**RE: CRANBROOK SCHOOL REDEVELOPMENT - SUBMISSIONS**  
**PPTY: 5 VICTORIA AVENUE, BELLEVUE HILL**

In support of our client's concerns, it has retained an independent transport planning consultant, namely TTPP (Jason Rudd, director) We are instructed to **submit** in support of our client's concerns TTPP's report dated 21 June 2018 ("**the Report**") which sets out their findings and recommendations

Figure 2 – Proposed On Site Drop Off – Pick Up Facility – Lack of Vehicle Storage

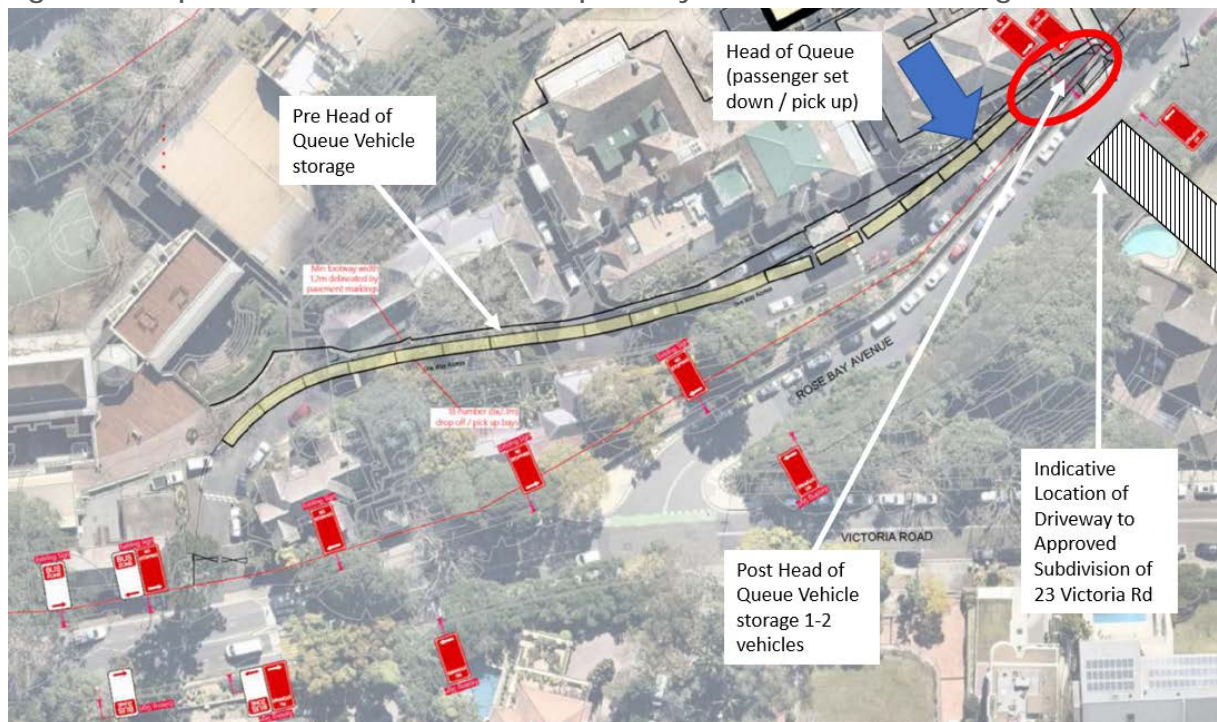
It appears that there has been a failure to undertake a proper assessment of the operational method of this drop off/collection formula. We note that TTPP have made recommendations given their experience and analysis of another school (Trinity), and in our view, their recommendation is sensible particularly given the fact that even within their internal road, congestion will be increased at the throat and it is likely to create vehicle queues leading along Victoria Road and possibly as far as to New South Head Road.

Page 7 of the Report states "no assessment and analysis of potential vehicle queuing or at the drop off/pick up exit to Rose Bay has been provided in the Traffic Report" nor has there been "...an assessment of the potential risks and mitigation measures for the high traffic volume driveway..." noting that "traffic flows will be highest simultaneously with high pedestrian flows."

Our client's primary position is that it supports the recommendation set out in the Report that as the drop off/collections are likely to require more than a 100m zone they should be relocated within the proposed car park.
